IMMINGHAM EASTERN RO-RO TERMINAL (TR030007)

Schedule of Amendments to DCO Application Documents

Section 51 Advice dated 2 February 2023

Drawing title		Lighting Project: ABP Humber, Project Sugar External Lighting SHEET 1 OF 3	
Drawing status		FOR COMMENT	
Scale	1:2500@A1	Suitability	S3
Jacobs No.	B2429400	Rev	
Client No.			P02
Drawing number		B2429400-JAC-00-ZZ-SK-ZZ-0150

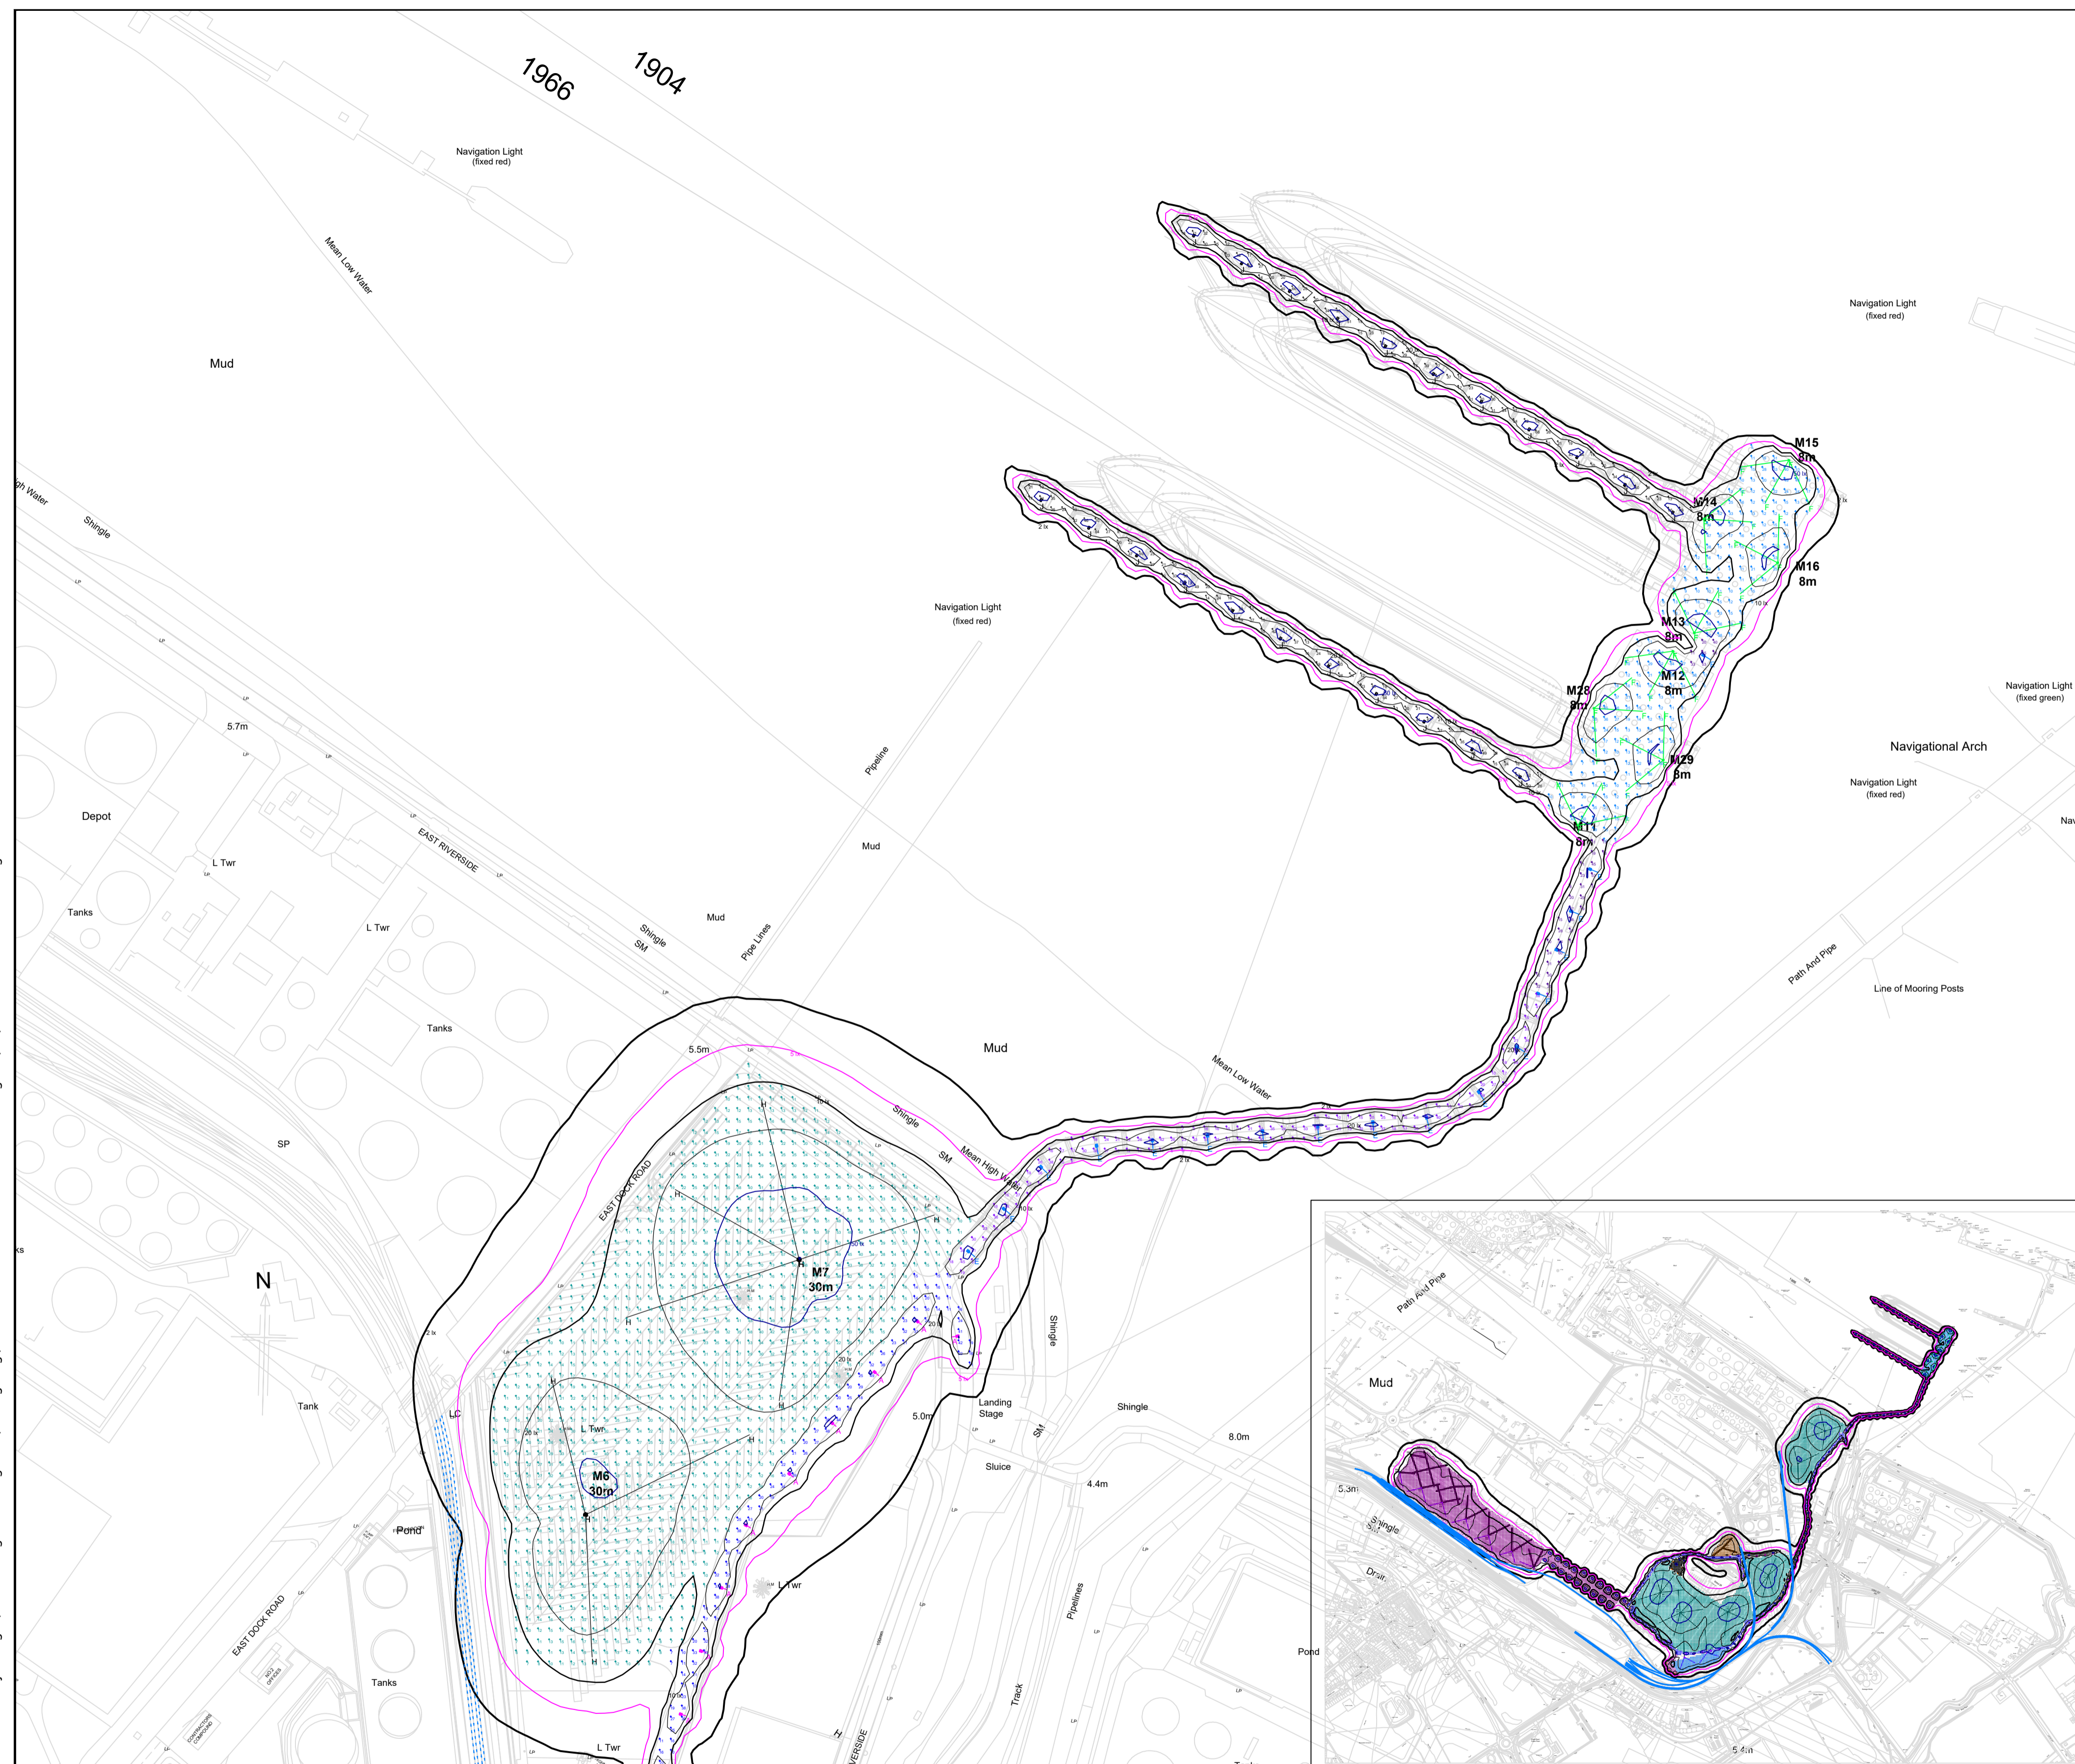
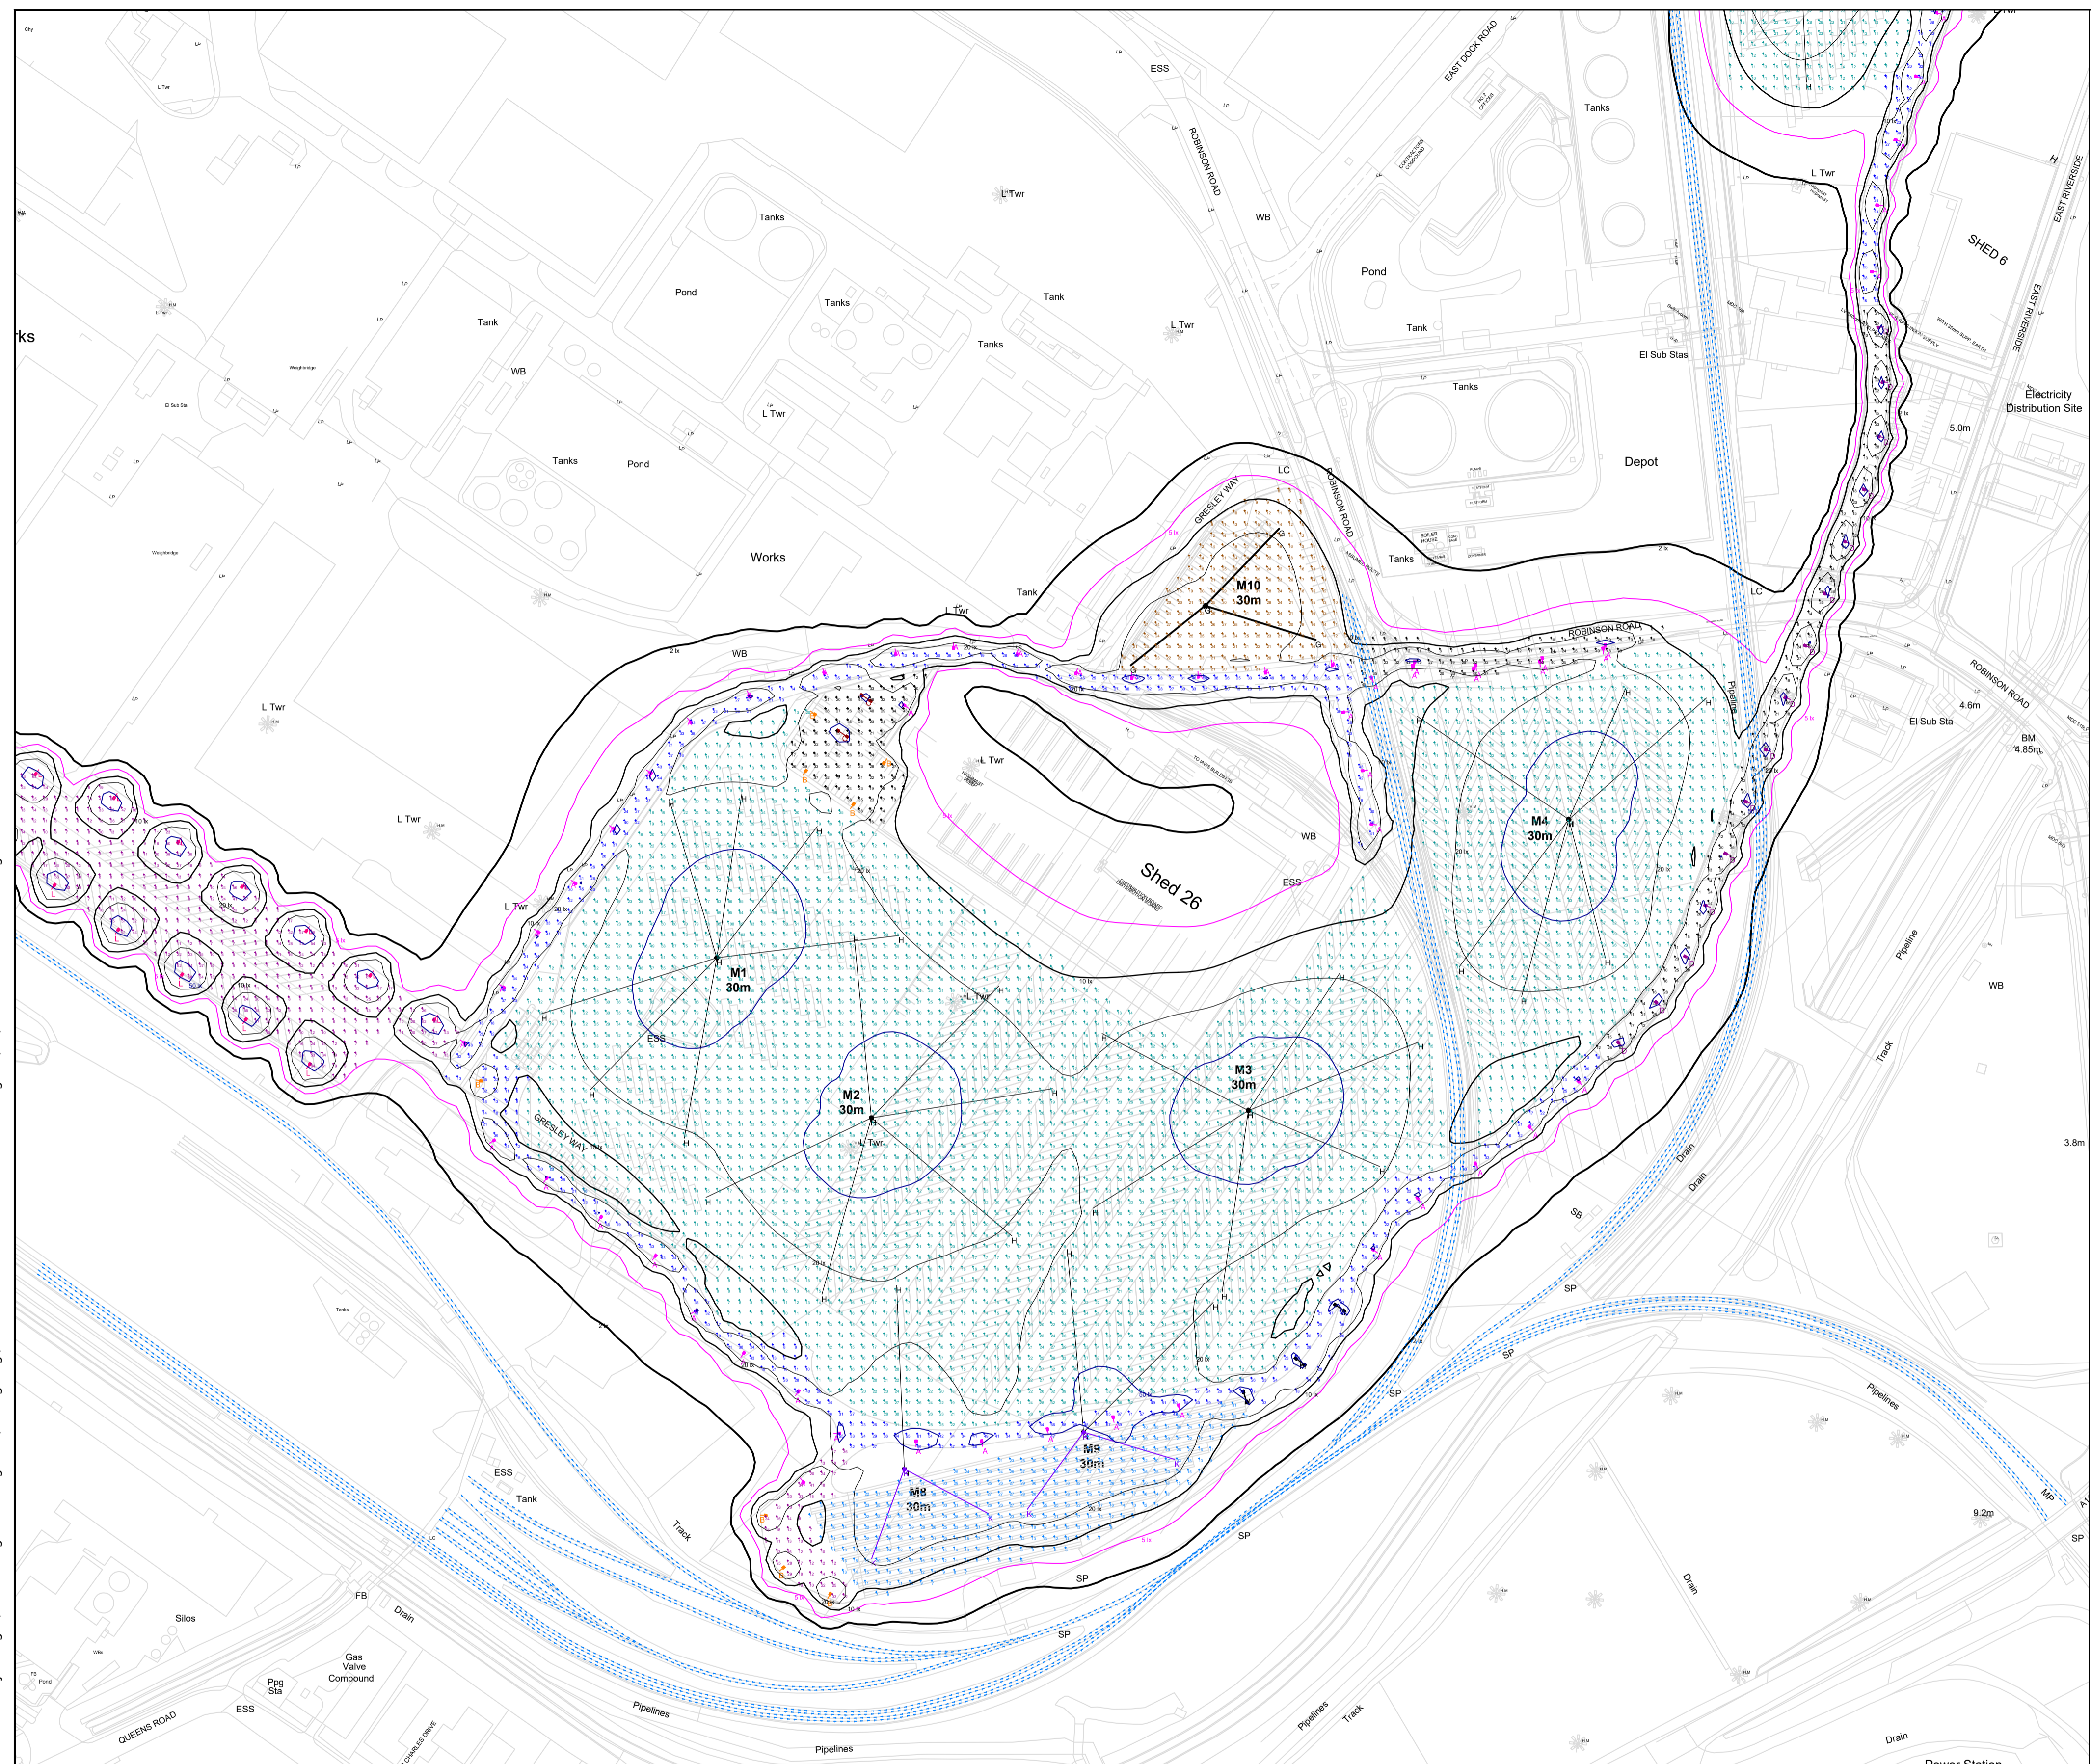
<p>Rochdale Envelope</p>	<ul style="list-style-type: none"> • The approach to the Rochdale Envelope has been clarified in Environmental Statement Chapter 2 Section 2.3 (Application Document 8.2.2). • Maximum building dimensions (which include UK Border Force facilities) are detailed in Environmental Statement Chapters 2 and 3 (Application Documents 8.2.2 and 8.2.3) • A Building Schedule defining maximum dimensions for all buildings has been added as ES Appendix 2.3 (Application Document 8.4.2 (c)). • The General Arrangement Plans including Rights of Way and Access Plans (Application Document 2.5) and Engineering Sections, Drawings and Plans (Application Document 2.6) have been amended to include building dimensions, but with the words ‘Do Not Scale’ removed. • The General Arrangement Plans including Rights of Way and Access Plans (Application Document 2.5), Engineering Sections, Drawings and Plans (Application Document 2.6), and Lighting Plan (Application Document 2.8) are amended to show lighting proposals. • Consequential amendments have been made to other application documents.
